**Consultation Response from KC,
Conservation & Design**

2023/90467 33, Wilshaw Road, Meltham, Holmfirth, HD9 4DZ

Demolition of electric gate and drystone wall and erection of new drystone wall and electric gate, extension of tarmac driveway (within a Conservation Area)

# Proposed site plan

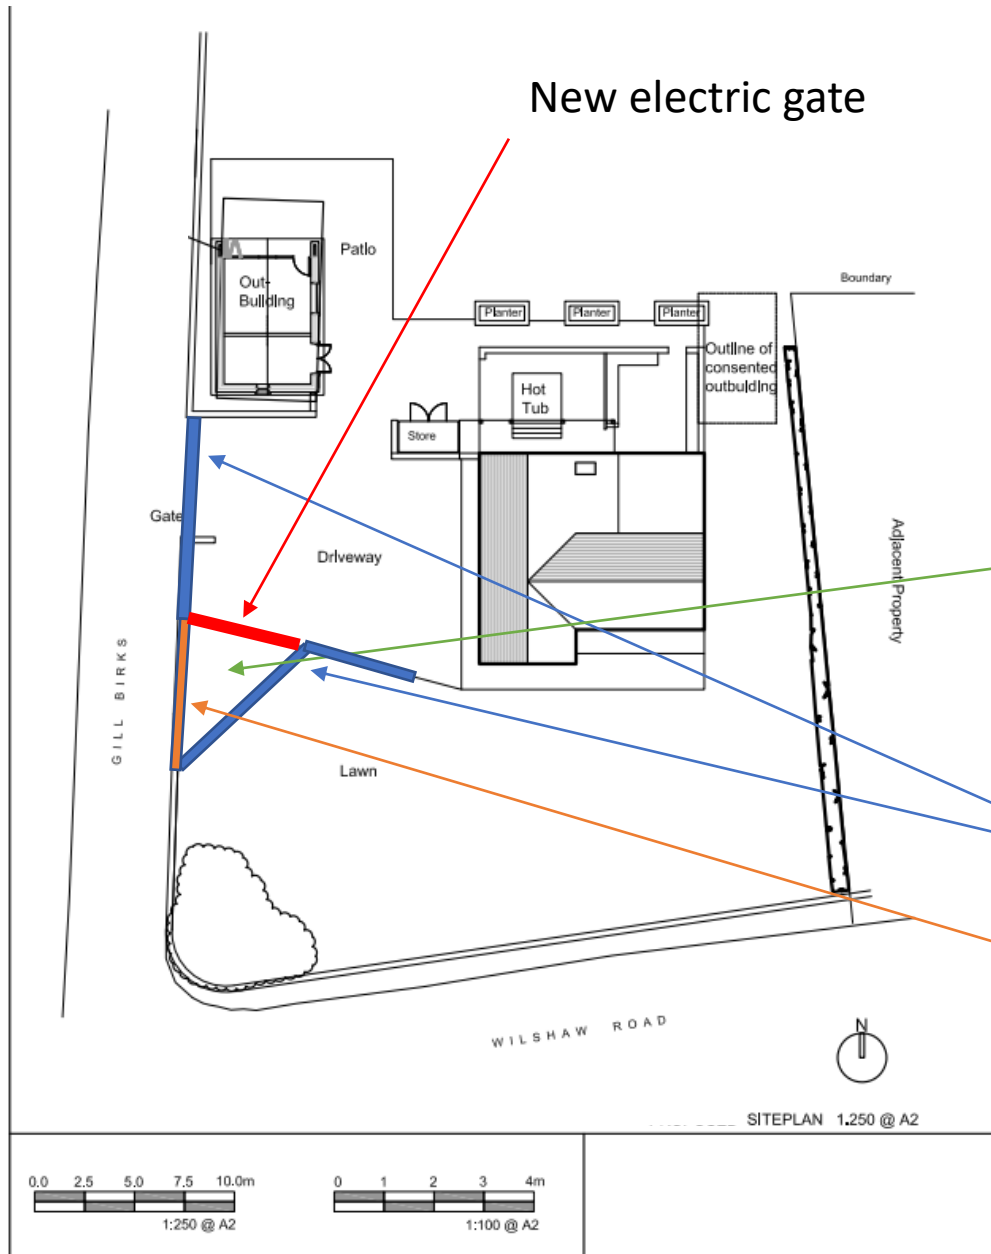
Having reviewed the submitted details, Conservation would not raise any concerns to the proposed works. While there will be some alteration to the boundary treatment, the use of drystone walling will provide some mitigation and appropriate detail.

We would however ask for additional details to be provided of the gate.
